Please ask for: Ms Iqraa Malik
Email: iqraa.malik@terraquest.co.uk
Telephone: 0121 234 1390
Our Ref: M/29/22/HH
Your Ref:
Date: 20th April 2022

Application for Planning Permission for Works or Extension to a Dwelling

Development: Erection of first floor side extension.
Location: Oakwood 102 Middleton Road Middleton-On-Sea PO22 6DL

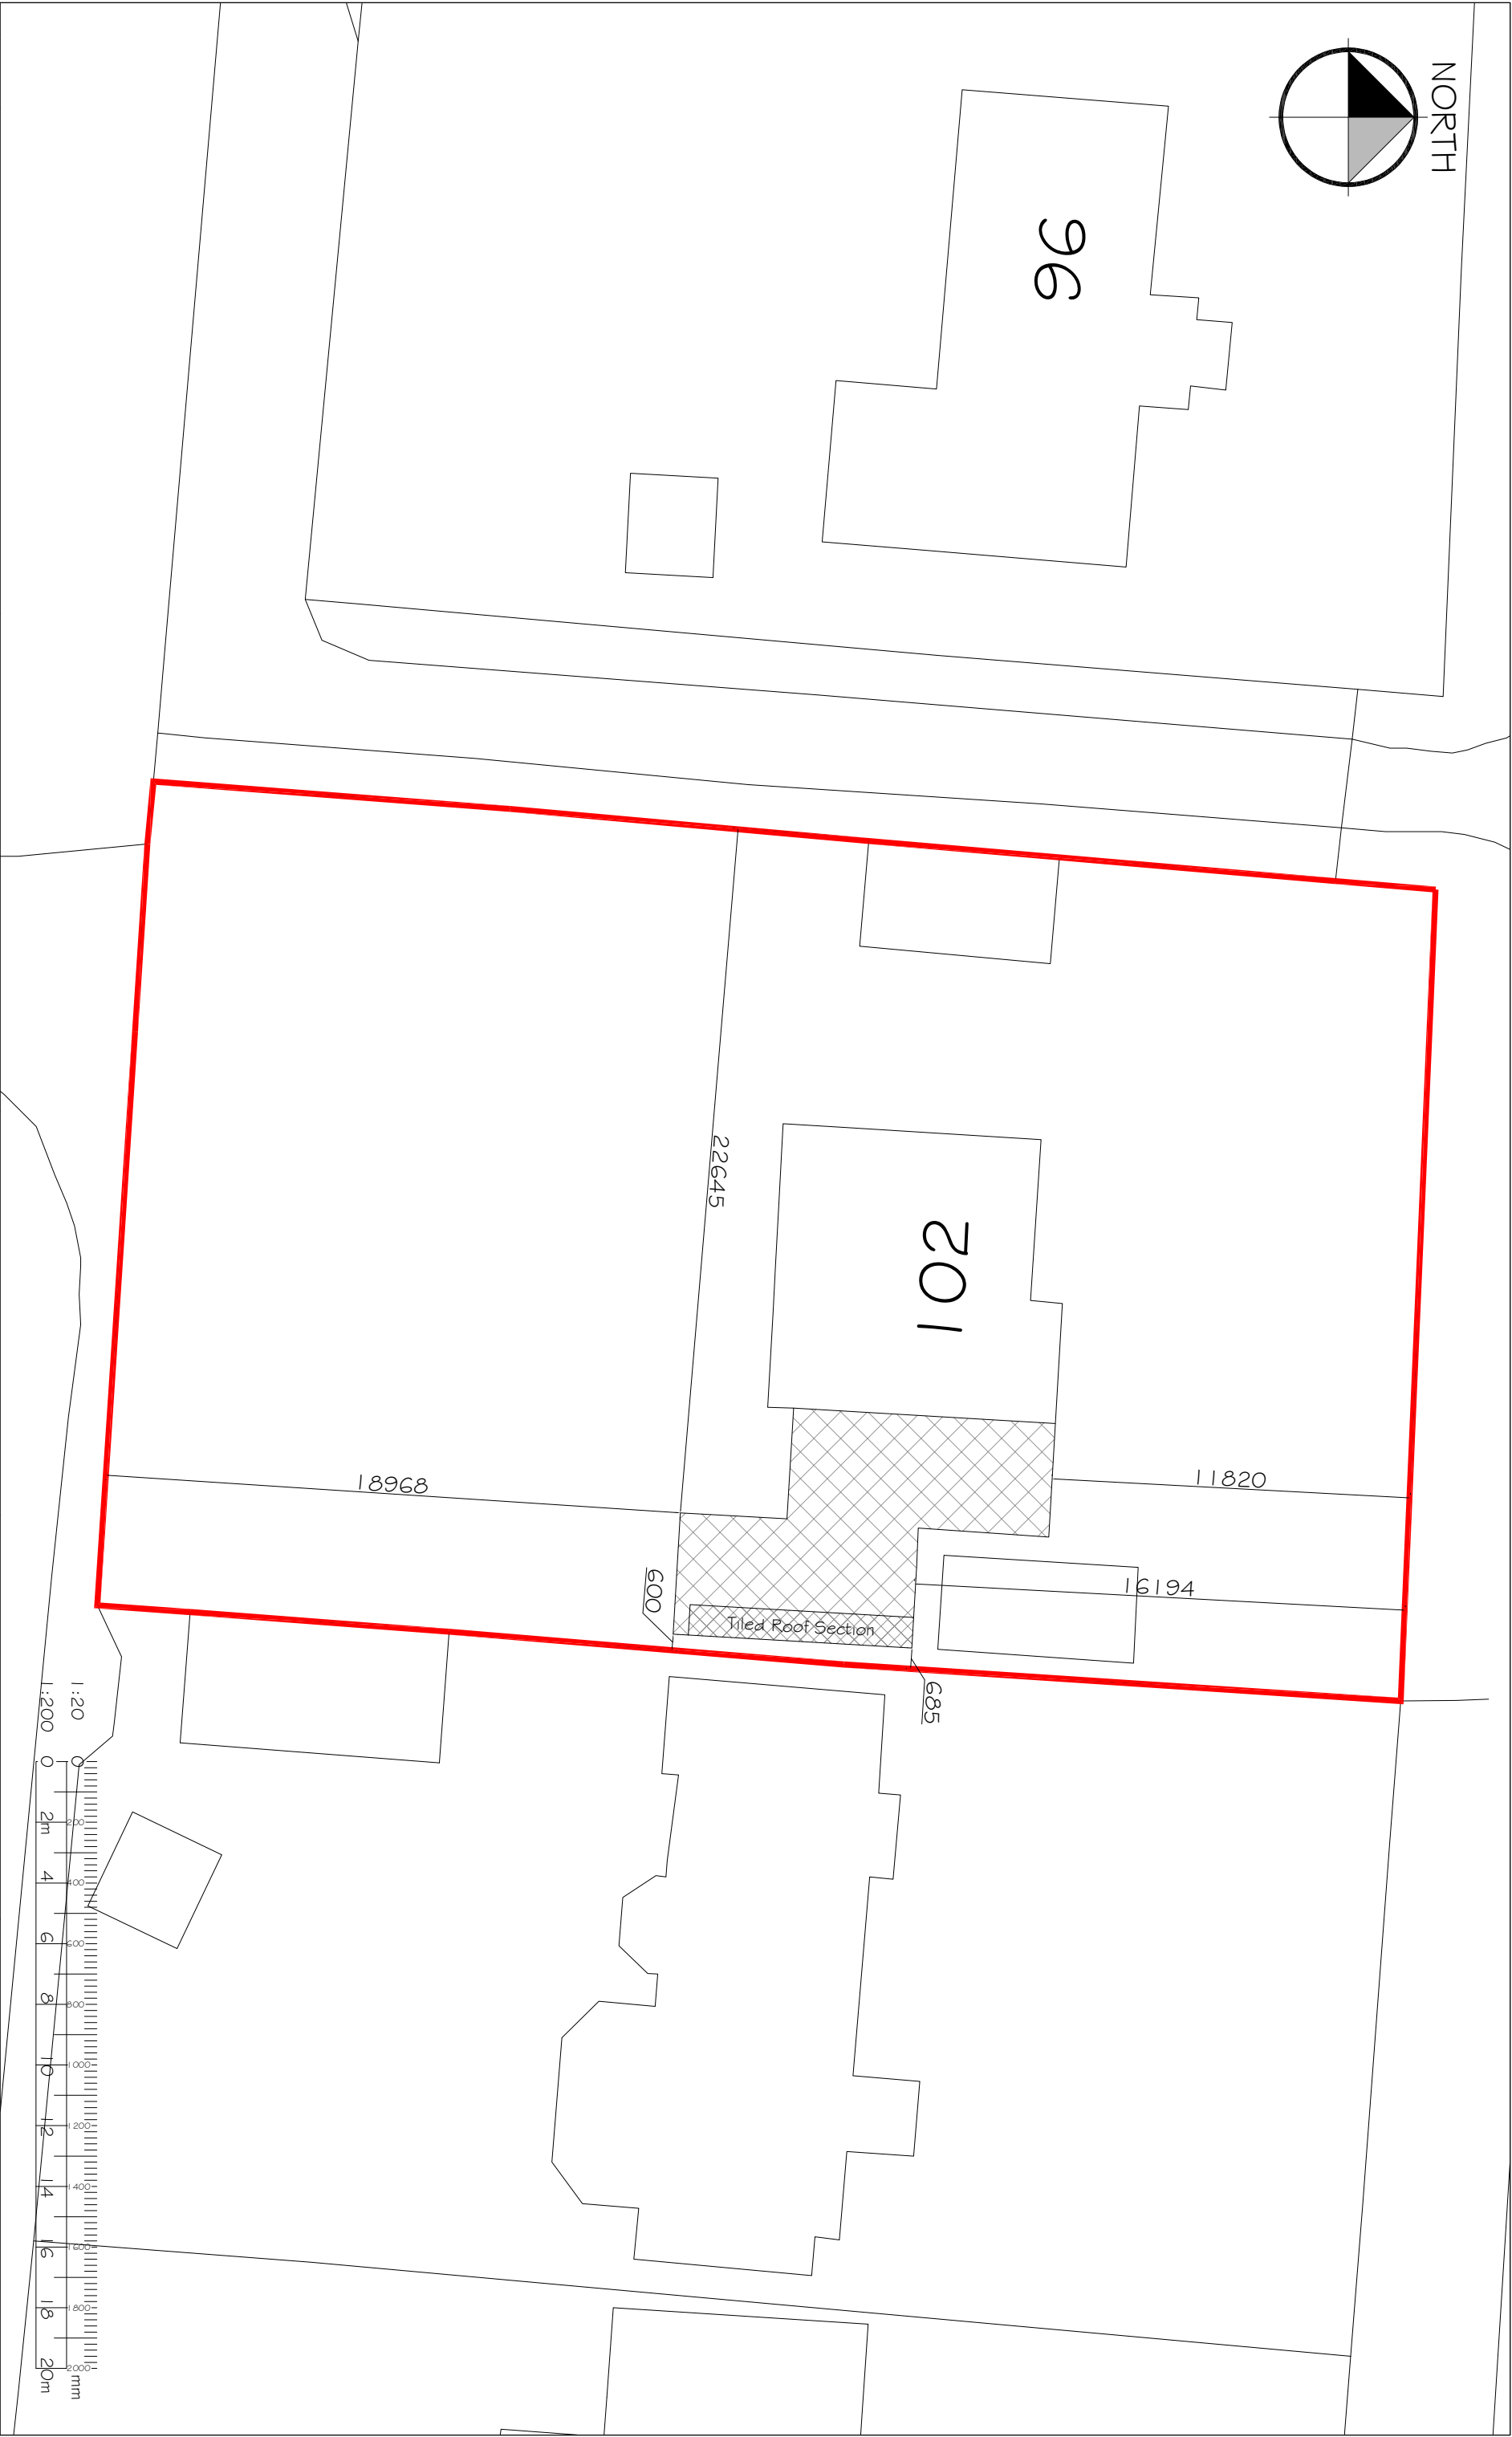
Block Plan

You are required to have dimensions from the proposed extension(s) to all site boundaries. Please amend.
